July 13, 2009

**Subject: Request for Modification to Individual Section 404 and 401 permits and Neuse Riparian Buffer Authorization** for construction of the SR 1923 Extension (Booker Dairy Road) from US 70 Business to US 301 in Johnston County. Federal Aid Project No. STP-1923(2). State Project No. 8.2312101. TIP No. U-3334. Debit \$570.00 from WBS 34929.1.1.

**References:** Section 404 Individual Permit issued March 17, 2009 (SAW 2008-02482);  
Section 401 Water Quality Certification and Neuse Riparian Buffer Authorization issued November 4, 2008 (DWQ No.20081106).

Permit Drawing
 Sheet 9 of 26

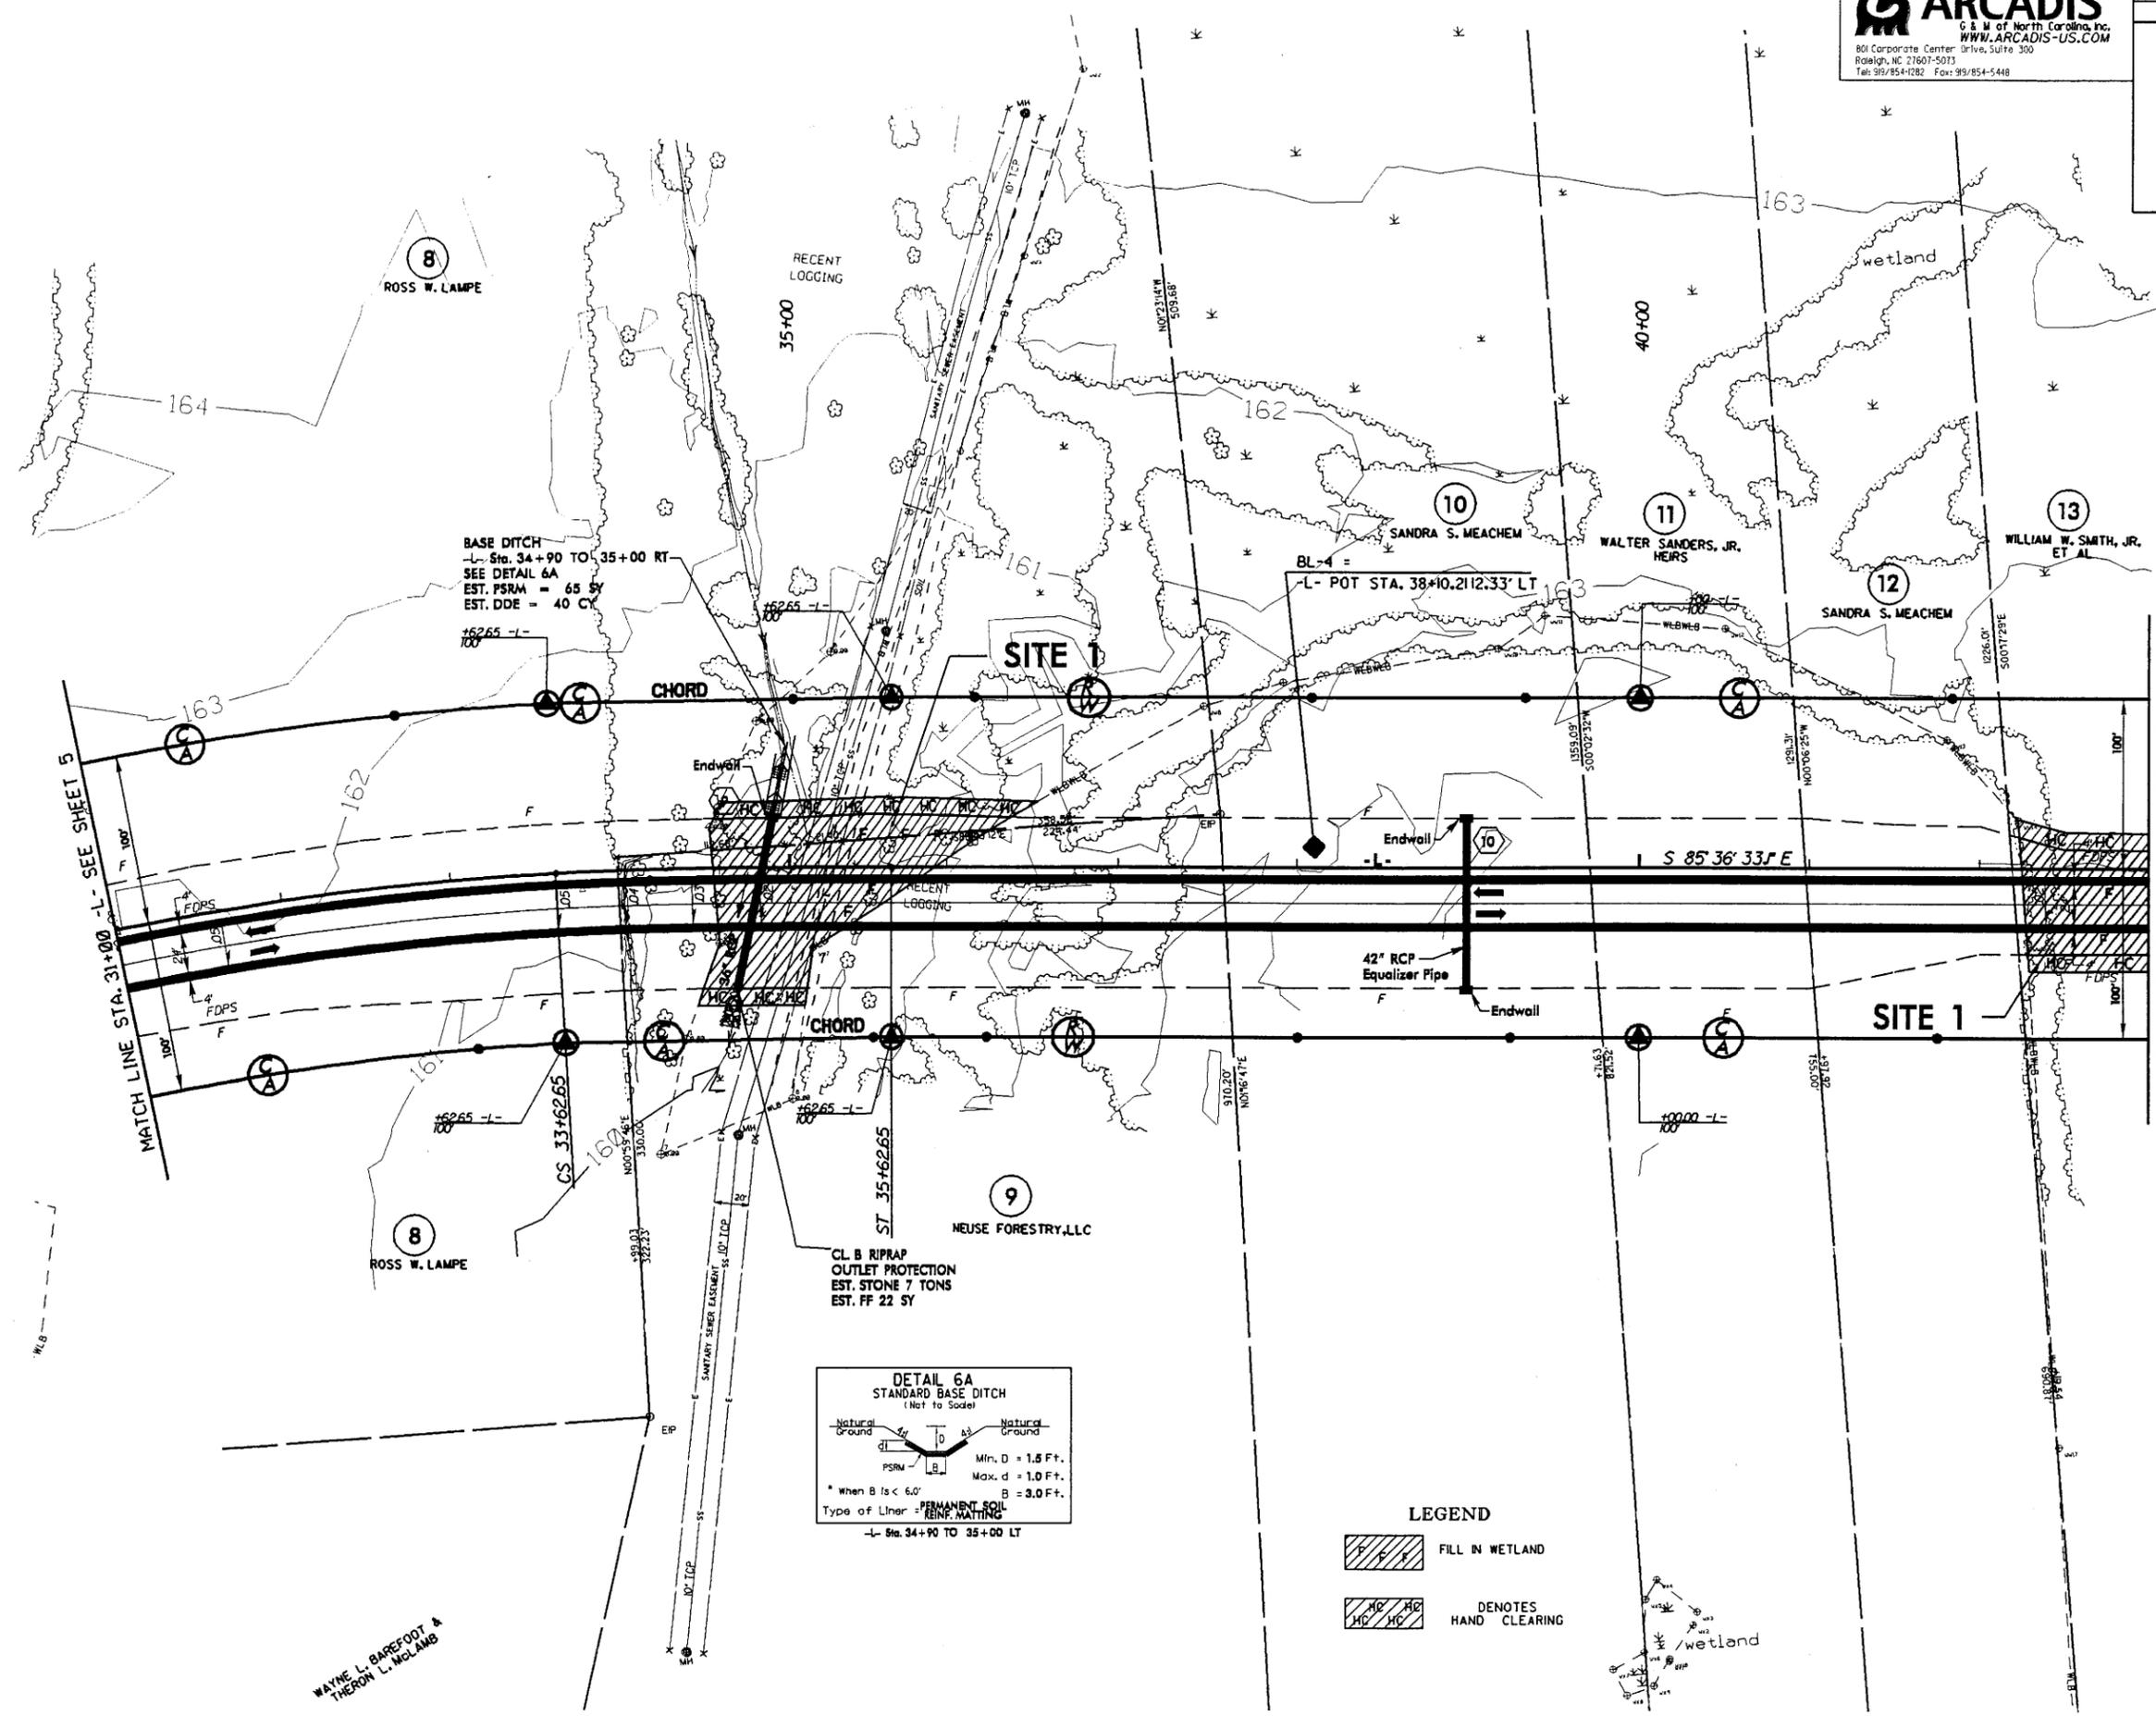
- Wetland site 1: a base ditch (station 35+00 RT) is shown extending beyond the fill line as permitted by the USACE and NCDWQ. NCDOT is proposing to move the inlet of the 36" RCP at this station to eliminate the unpermitted impact associated with the ditch. On the opposite end of this ditch (station 35+00 LT), a Class B Outlet Protection dissipation pad is shown extending approximately 25 feet outside the permitted fill line. NCDOT is requesting <0.01 acre of permanent fill for the pad and an additional 0.02 acre of mechanized clearing to install this device. In addition, the impacts associated with the sewer pipe being replaced east of this ditch

did not account for temporary ground disturbance around the pipe itself outside the permitted fill line. However, NCDOT is proposing that the work area required for the installation of the sewer line be confined to the existing sewer easement for the Town of Smithfield. Given that this easement is 20' wide and maintained in an herbaceous state, the maximum amount of hand-clearing, if needed, would be 0.04 acre. Finally, there are 4 equalizer pipes at wetland site 1 that extend into hand-clearing areas outside the fill slope. Division 4 has asked that 0.03 acre of hand-clearing originally permitted be replaced with mechanized clearing in these areas to perform the pipe installation. With these changes, permanent wetland impacts at this site now total 1.96 acres.

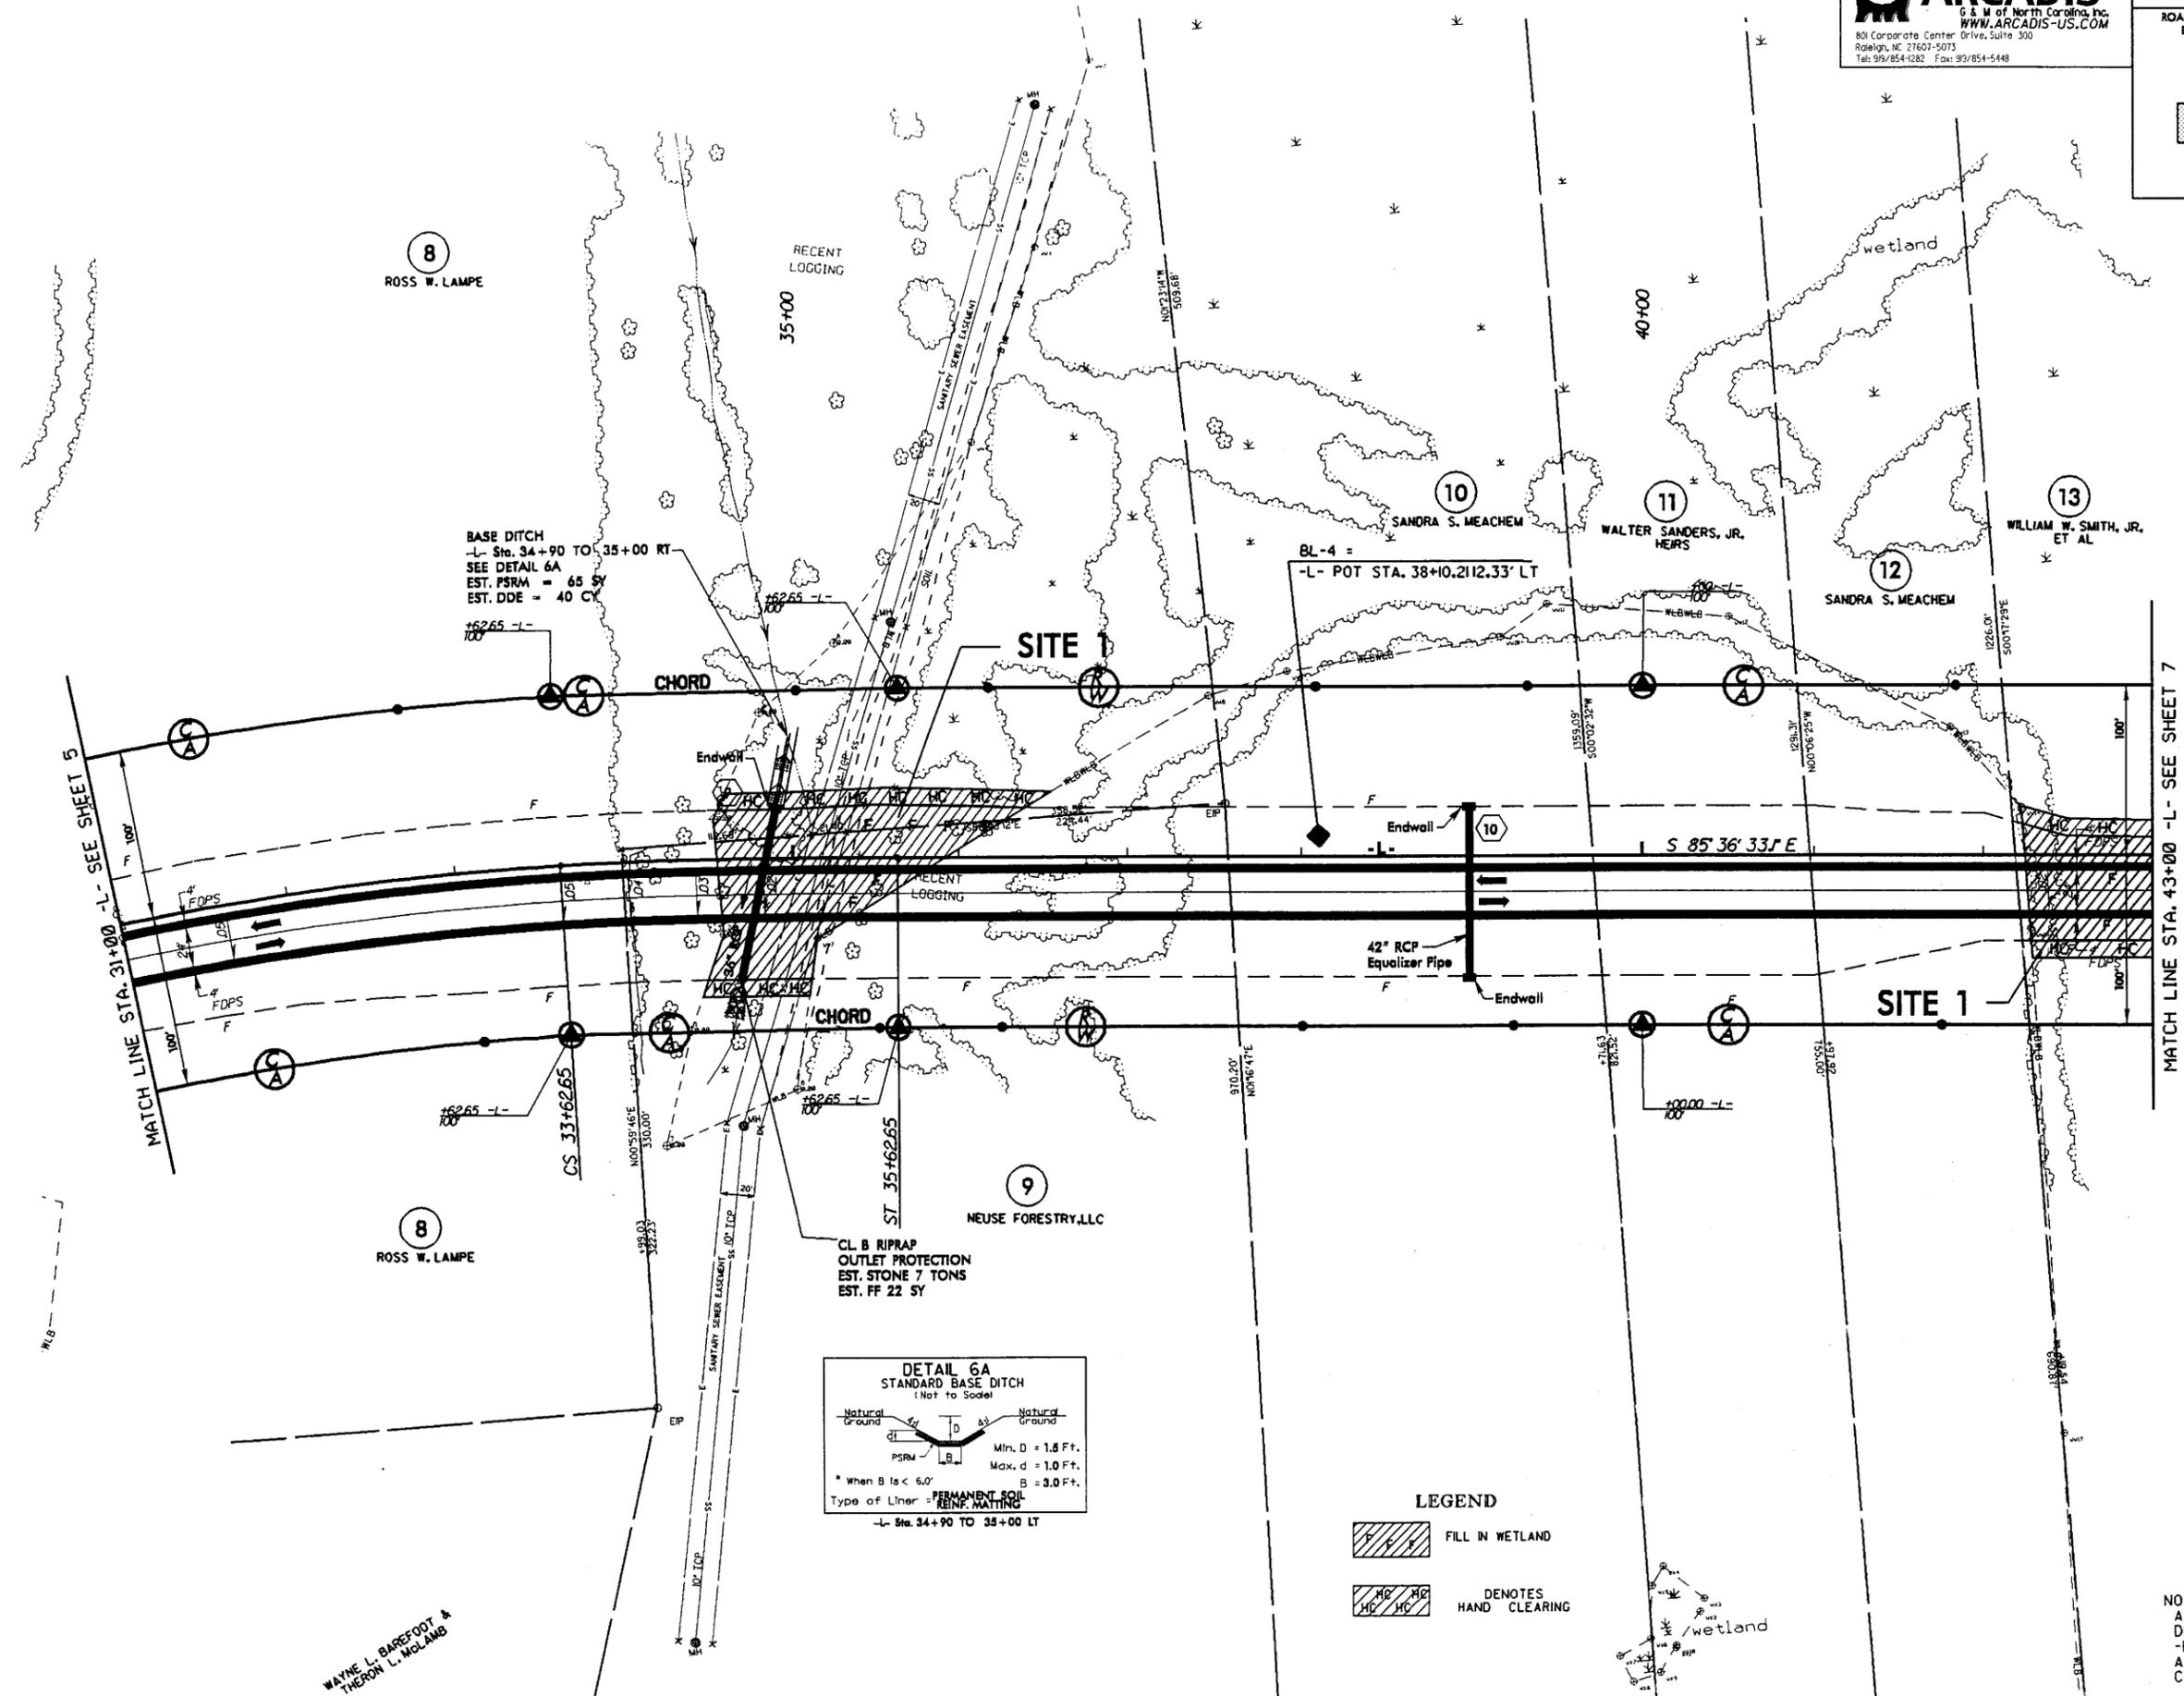
- Wetland site 2, a Class B Outlet Protection dissipation pad is to be installed in an area only permitted for hand-clearing by the plans. Therefore, NCDOT is requesting <0.01 acre of permanent fill for the pad and an additional 0.02 acre of mechanized clearing at this site to perform the needed work. Therefore, the total amount of permanent wetland impacts at this site is now 0.07 acre.
- Wetland site 5: NCDOT is requesting an additional 9 linear feet of stream impacts due to a miscalculation in the original permit application. The total amount of permanent impacts at this site should be 78 ft.
- Buffer site 3: a 42" RCP is replacing the 36" RCP that was originally permitted. This change does not result in any additional buffer impacts.
